3 July 2019

**Re: SECTION 4.55 (1A) MODIFICATION APPLICATION TO SSD 7751
BULLI HOSPITAL AGED CARE CENTRE OF EXCELLENCE
22 HOSPITAL ROAD BULLI**

This Modification Application has been prepared by TCG Planning on behalf of Health Infrastructure NSW, seeking consent to modify various aspects of the SSD 7751 approval at 22 Hospital Road, Bulli (the subject site) pursuant to Section 4.55(1A) of the *Environmental Planning and Assessment Act, 1979* (EP&A Act).

P: 02
F: 02
W: www.hinfra.health.nsw.gov.au
PROJECT
BULLI AGED CARE CENTRE OF EXCELLENCE
DRAWING TITLE
ELEVATIONS - PROPOSED - SHEET 2

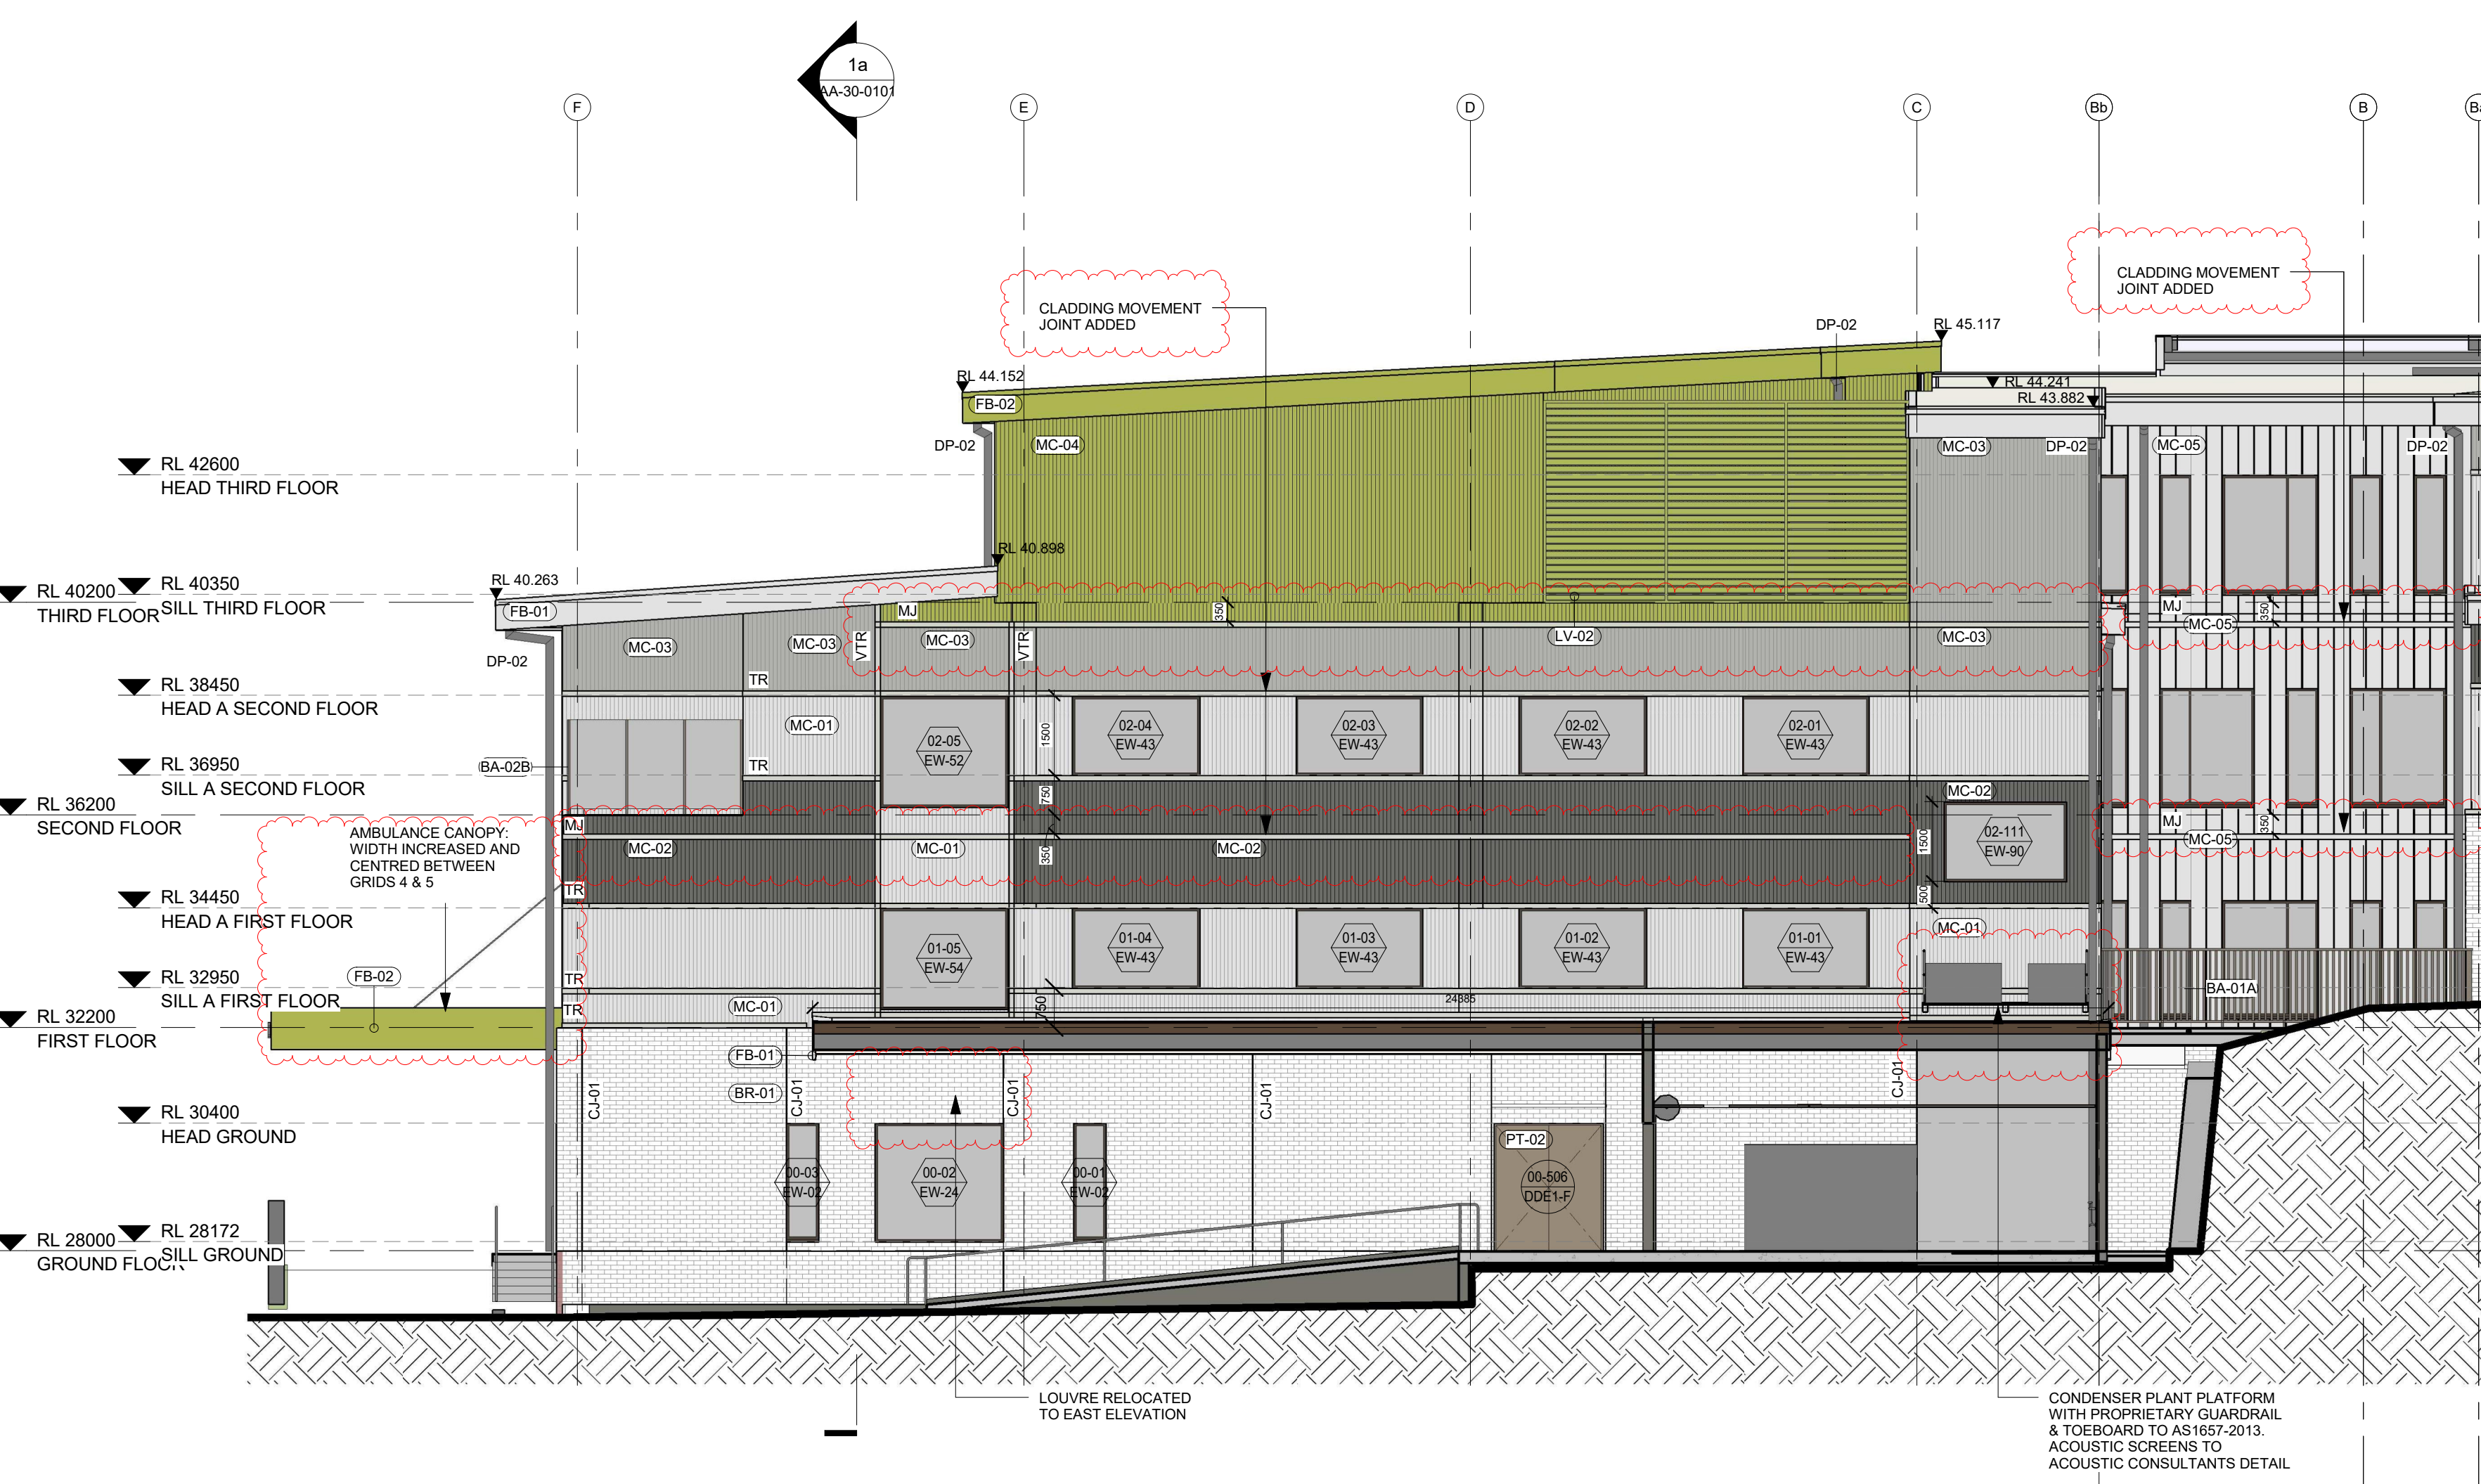
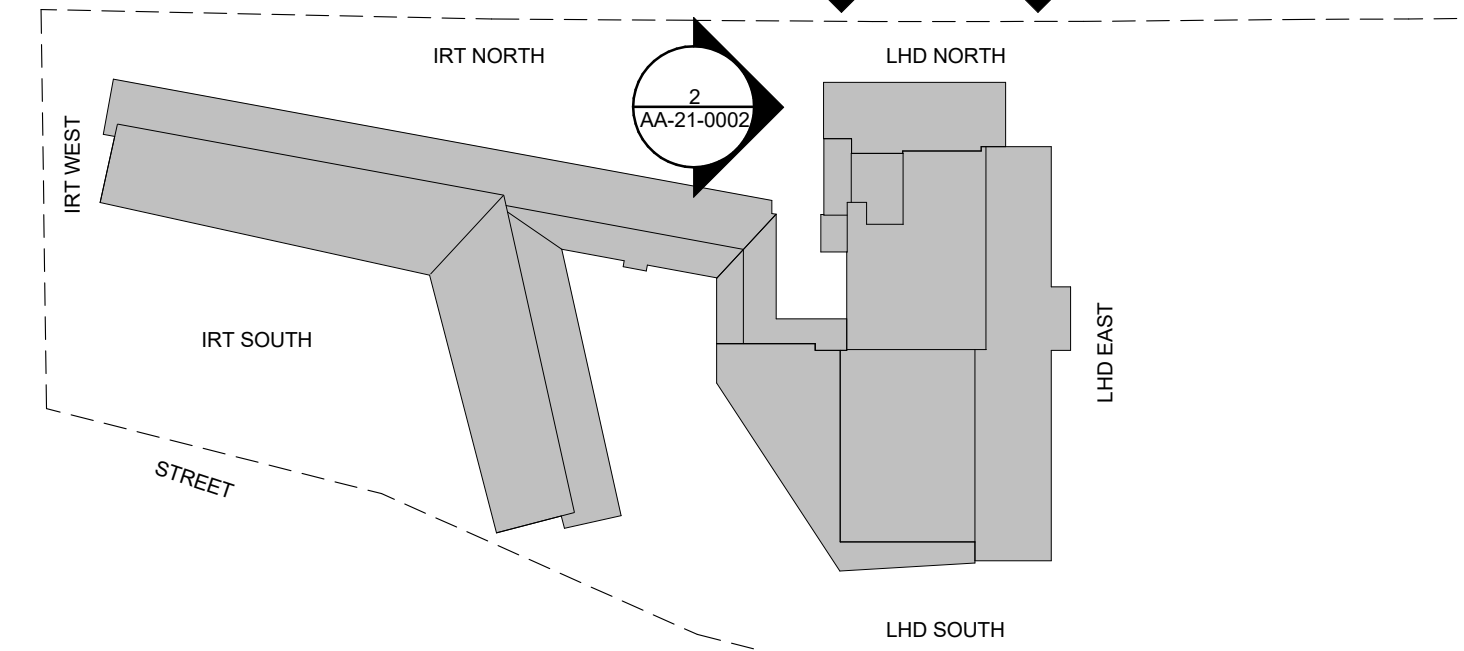
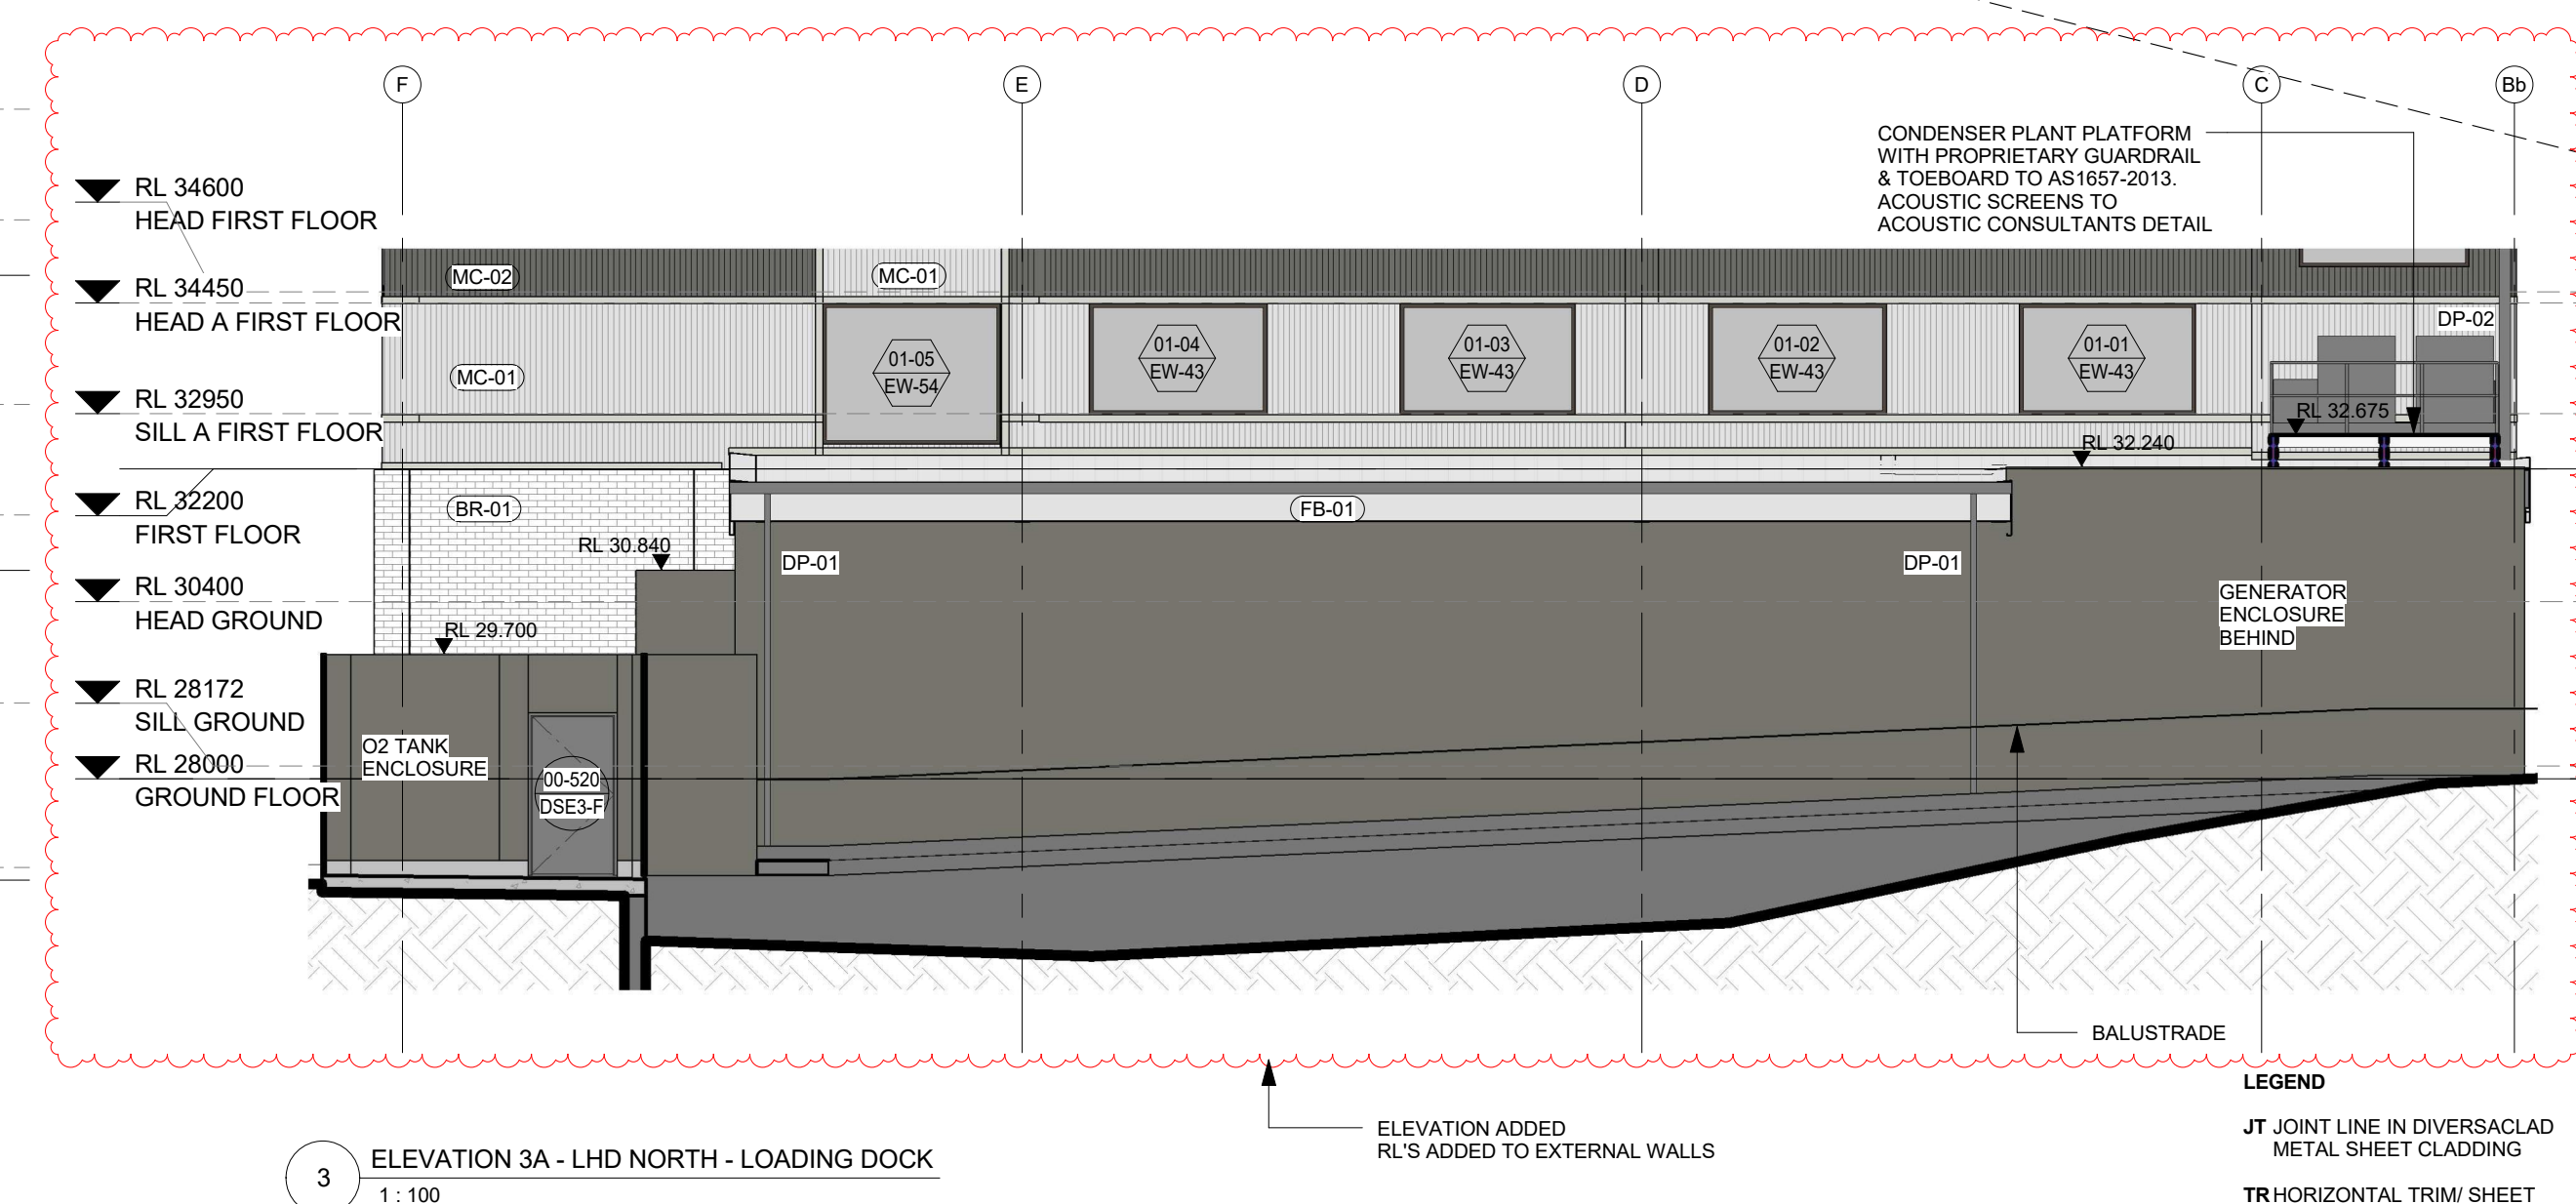
Patient Transport awing Redesign	Billard Leece Plan Dwg: AA-06-0102	The Awning over the Patient Transport entrance has increased in size and now has tension rods externally.
Loading Dock - Generator Enclosure	Billard Leece Plan Dwg: AA-06-0101 and Elevations Dwg: AA-21-011 and AA-21-012	Generator enclosure wall heights not shown on DA Set. If scaled off DA drawings this wall is now required to be 700mm higher. This is to meet acoustic requirements.
OSD Tank Acoustic Walls	Billard Leece Plan Dwg: AA-06-0101 and Elevations Dwg: AA-21-0001 and AA-21-0002	Acoustic Walls to the OSD Tank were not shown on the DA Set. This wall is required to be 1.3m high as a crash barrier to the loading dock. The adjacent neighbour requested this wall be increased to 2.4m high.
Oxygen storage Acoustic Walls	Billard Leece Plan Dwg: AA-06-0101 and Elevations Dwg: AA-21-0001 and AA-21-0002	Wall to oxygen enclosure proposed to be reduced in height to match height of OSD Tank Wall.

Mechanical Plant – not shown on DA Set	Billard Leece Plan Dwg: AA-06-0101 and Elevations Dwg: AA-21-0001 and AA-21-0002 Correspondence by Acoustic Logic	There are five condenser units that need to be installed in front of Stair 2. Acoustic screens required.
Landscaping Changes – deletion of tree	Billard Leece Plan Dwg: AA-06-0101	Deletion of 1 tree adjacent to Car Space No. 18. Concrete slab required in this area to support adjacent retaining wall and crash barrier.
Change building identification sign	Billard Leece Plan Dwg: AA-21-0003 (Elevation)	Main building sign to be changed to reflect name change from "Bulli Aged Care Centre of Excellence" to "Bulli Hospital and Aged Care Centre"
Changes to external materials and finishes (addition of Bike Racks)	as detailed in Materials Schedule Revision 6 dated 18.04.19 provided by Billard Leece Partnerships Pty Ltd	Bike racks added in different location adjacent to car parking areas.
